DEVELOPMENT FACILITATION TEAM

Planning - Case Comments

Project Number: PR-2023-009368

Project Name: Farolito Senior Community

**C1 SOUTH ELEVATION**  
3/32" = 1'-0"

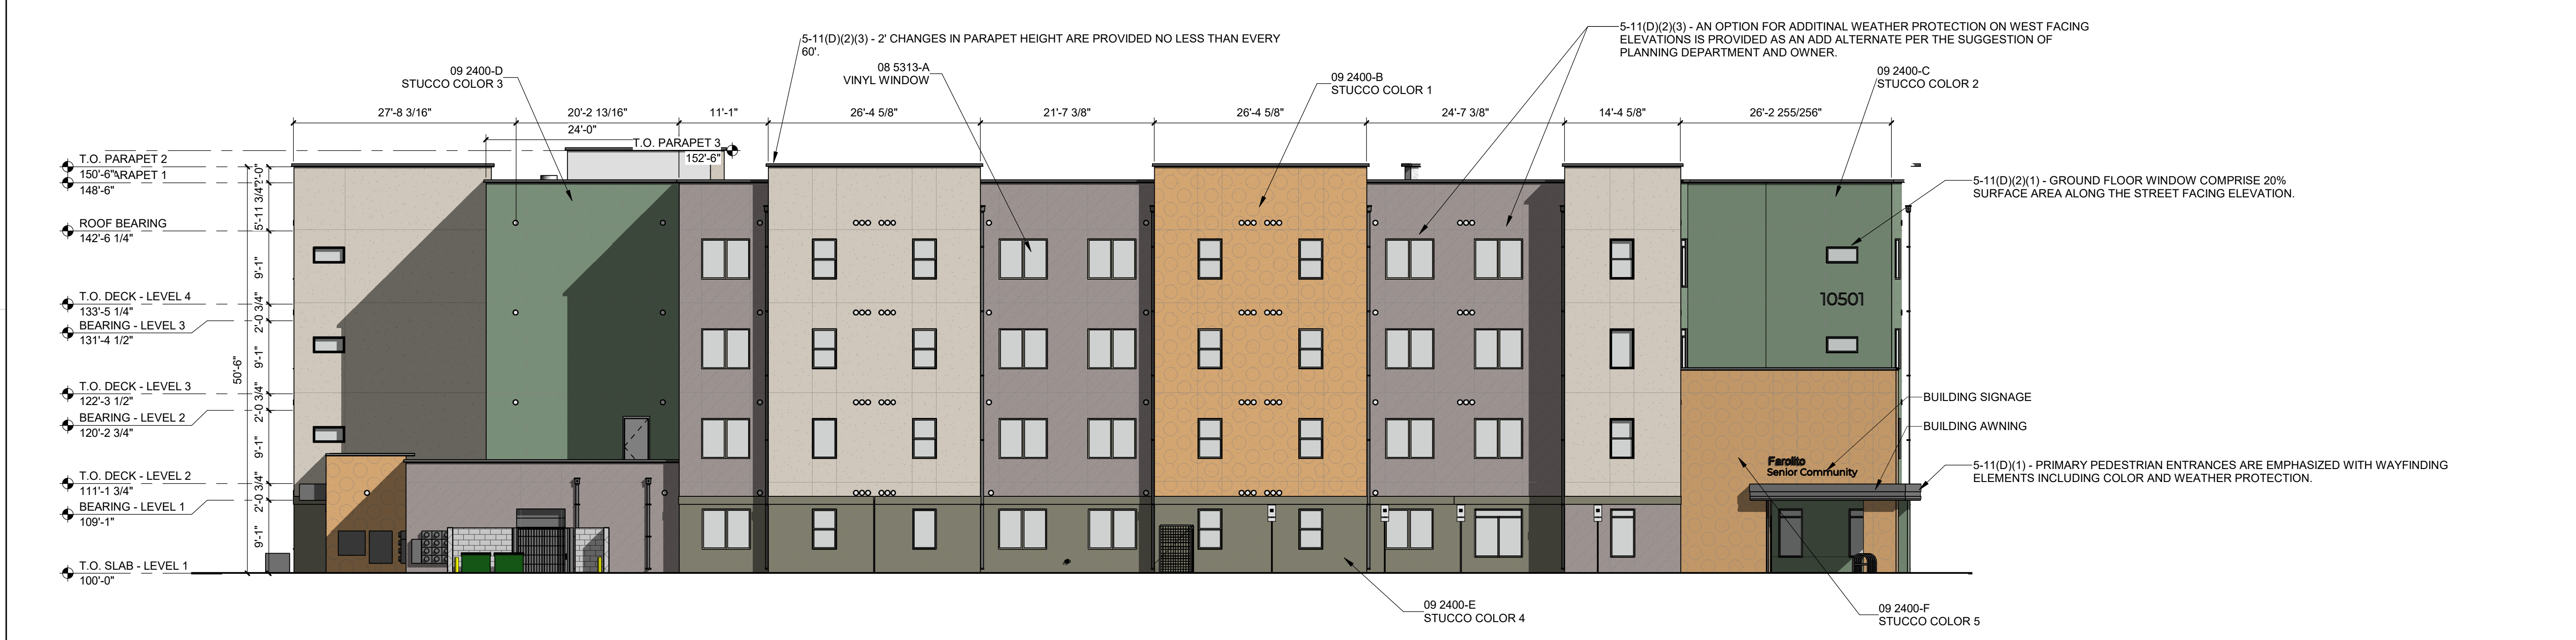
- 5-11(D)(2) Façade Design,
Per 5-11(D)(2)(a) Windows:
 1. Street-facing ground floor must have 20% in transparent windows.
 2. Windows recessed 2 inches or have a 2-inch casing.
 3. West facing windows must use heat mitigation.

Please articulate how the facade design meets these criteria.

Design complies with this code. Please provide an explanation for the façade color selection. If the intent is to mimic the Luminaria project across the street, please consider providing more non-grey colors on the façade.
